KITTITAS COUNTY COMMUNITY DEVELOPMENT SERVICES

September 11th, 2017

RE: Yakama Nation Boundary Line Adjustment,

Map Number	18-18-19010-0014	Parcel Number	21218
Map Number	18-18-19010-0002	Parcel Number	029433
Map Number	18-18-19010-0015	Parcel Number	21220

RECORD SURVEY FOR A BOUNDARY LINE ADJUSTMENT FOR THE YAKAMA KLICKITAT FISHERIES PROJECT

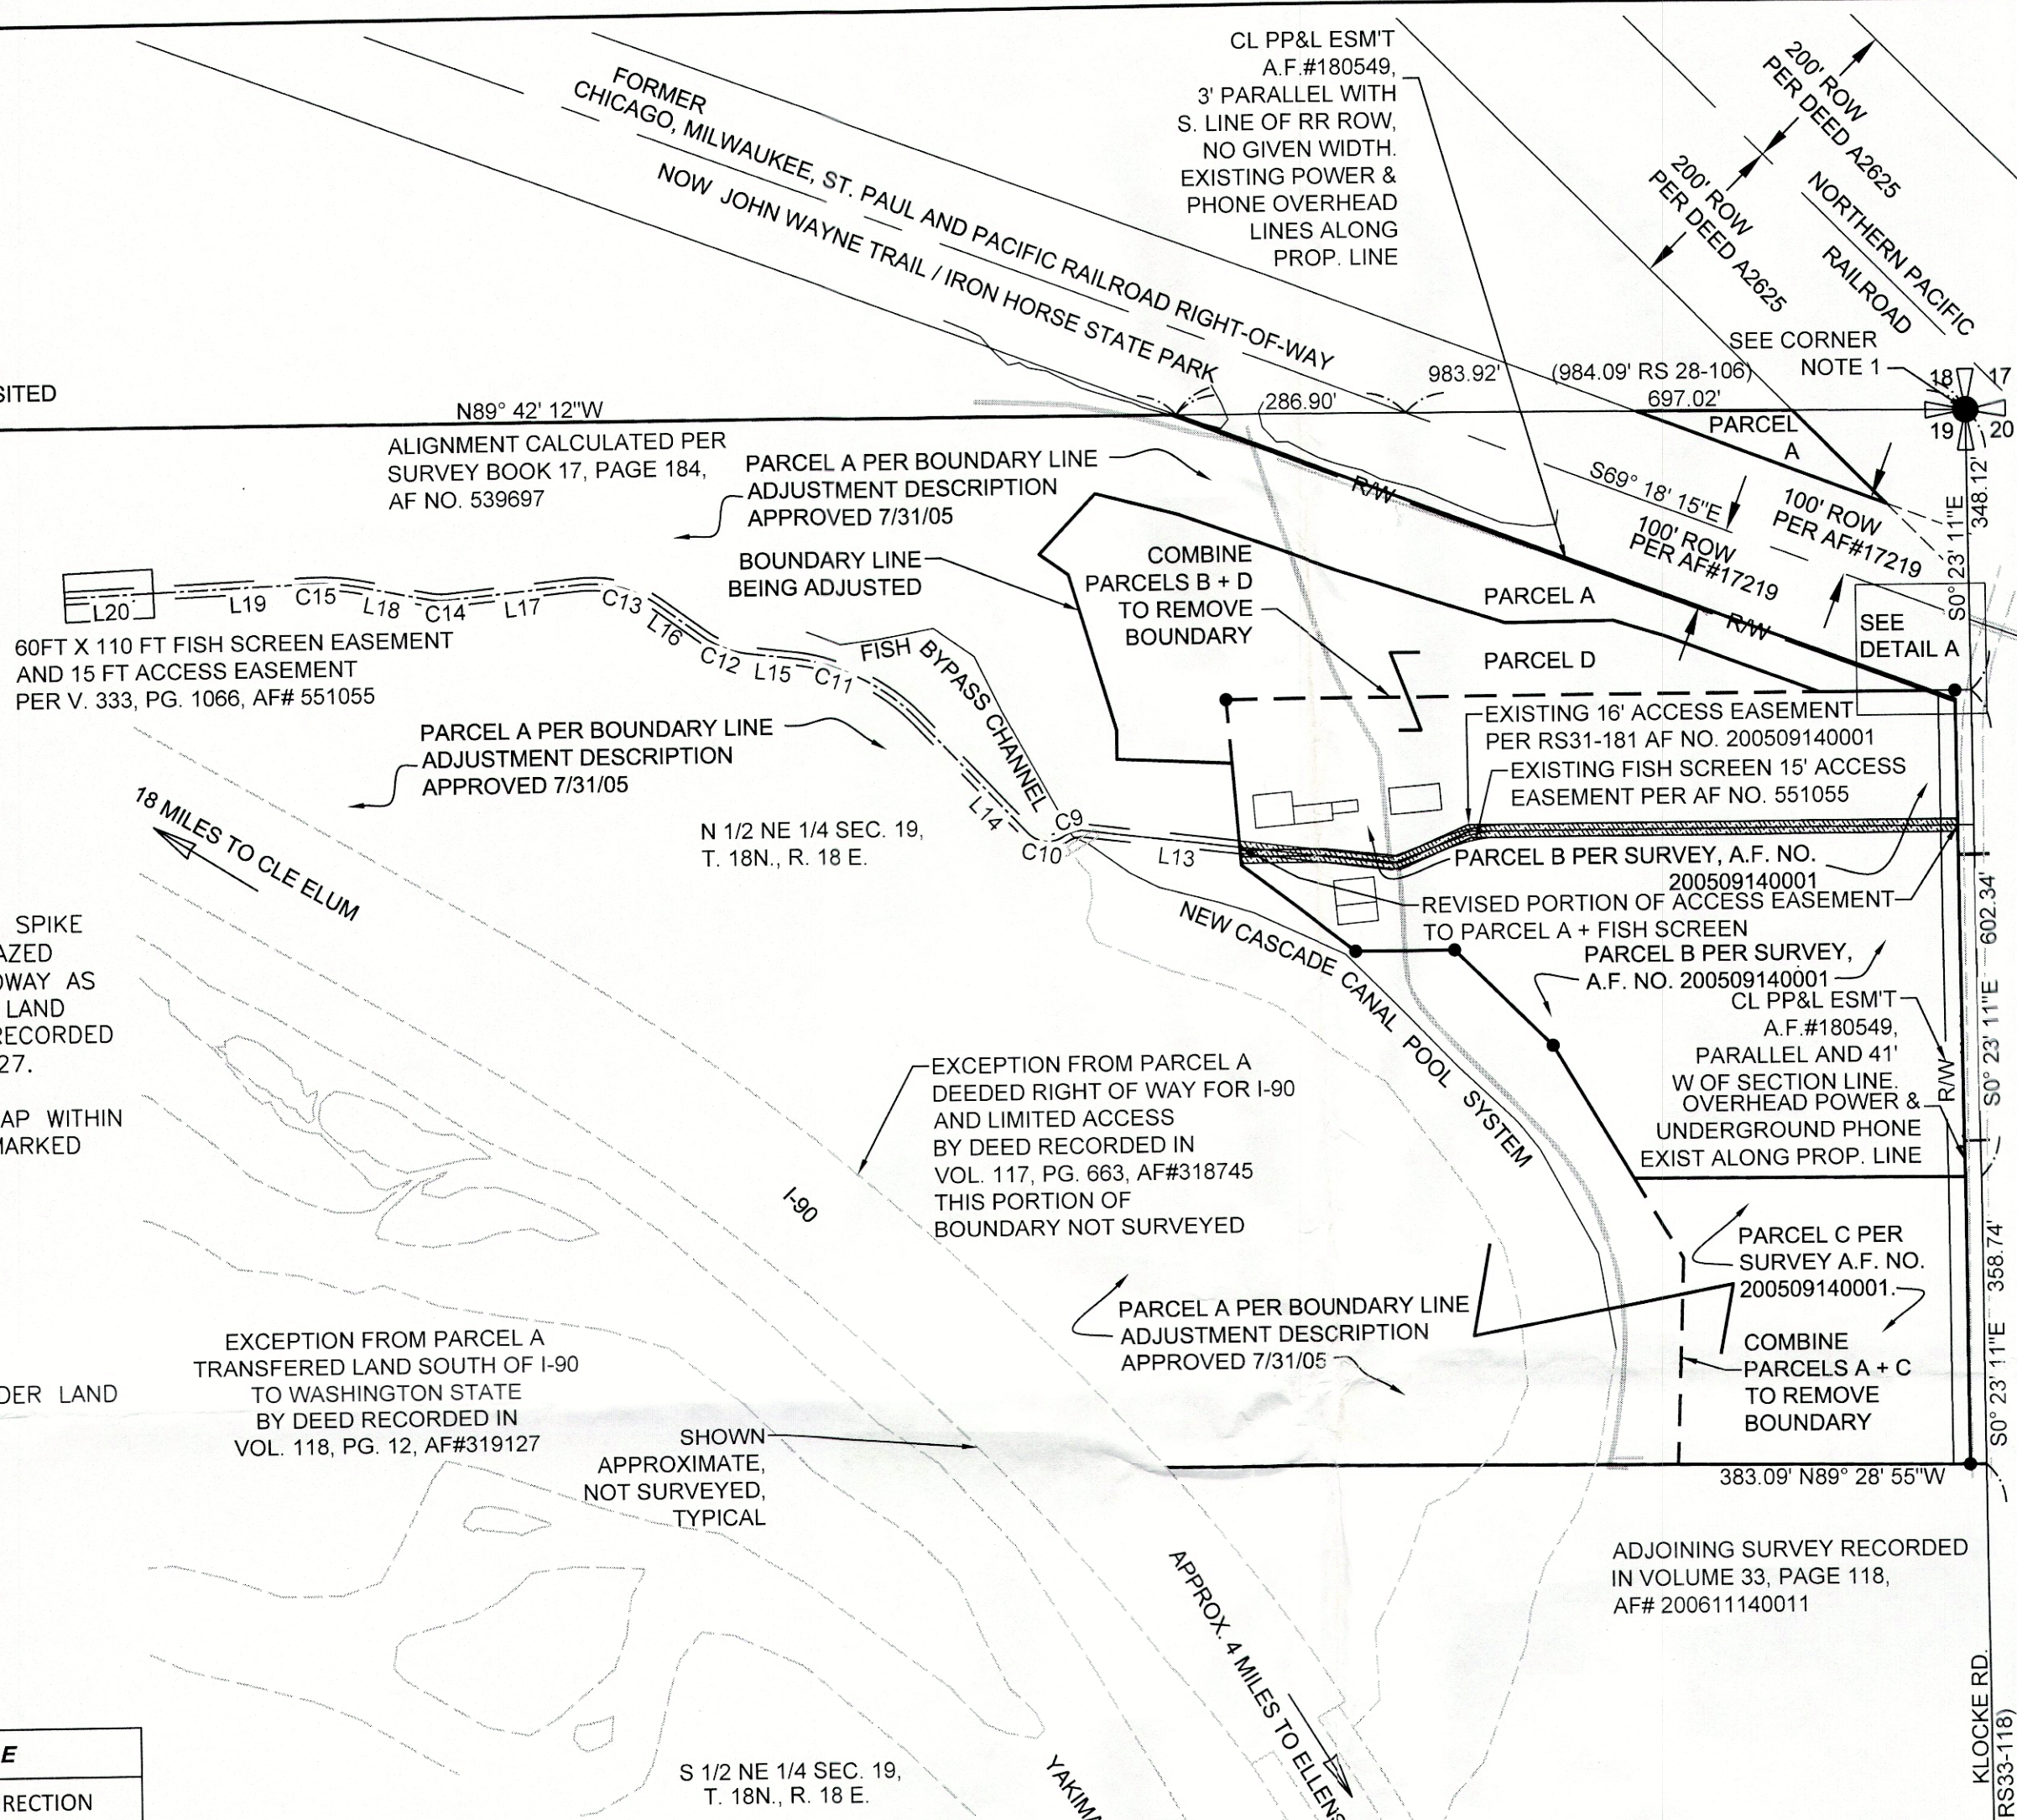
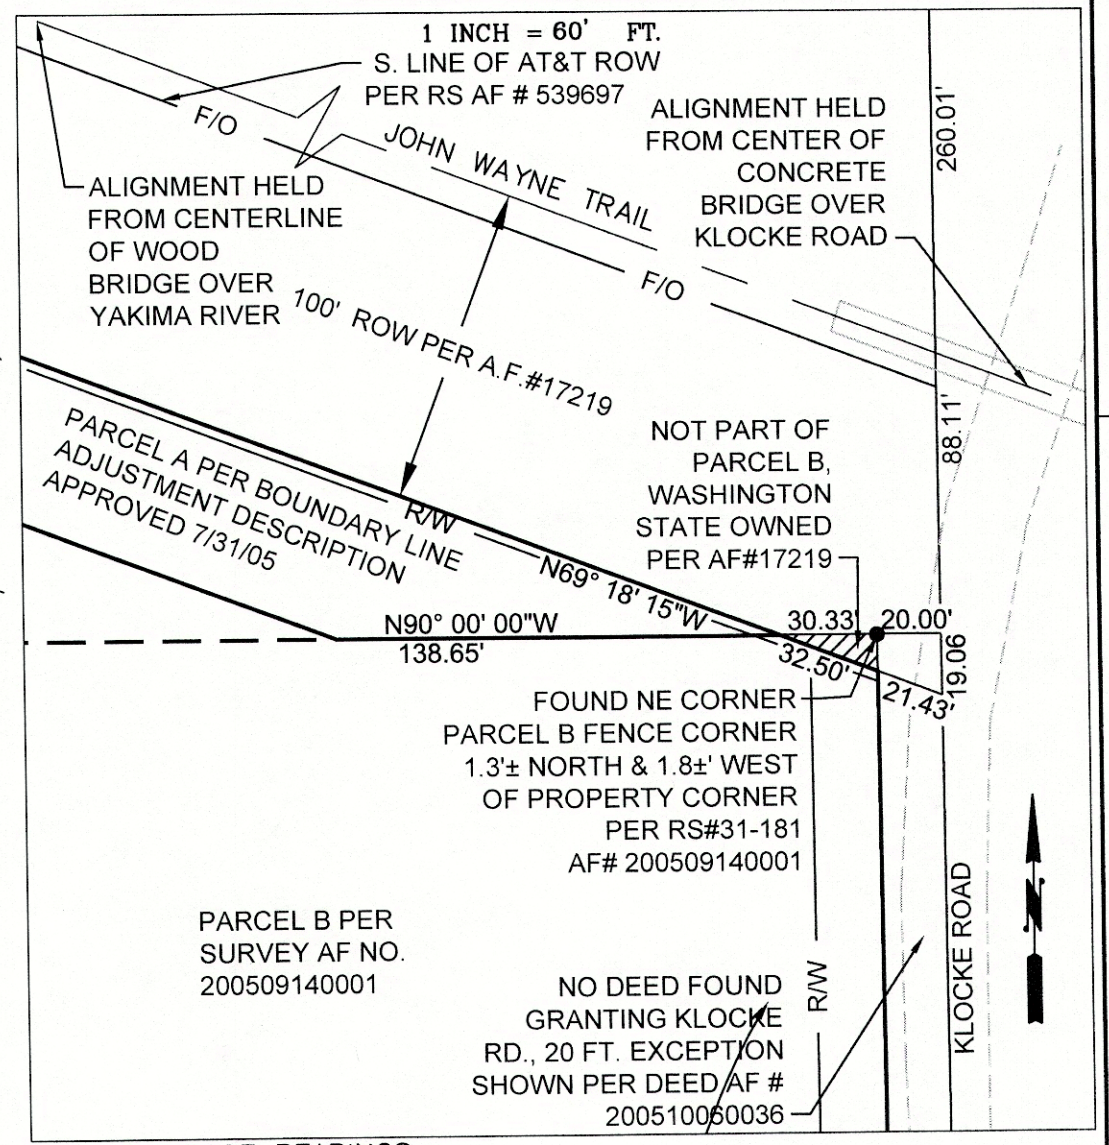
2. The preliminary survey shows a 20 foot rear setback to the main building, while the Agriculture 20 zone requires a 25 foot setback. The recorded survey must show that all setback requirements are met.
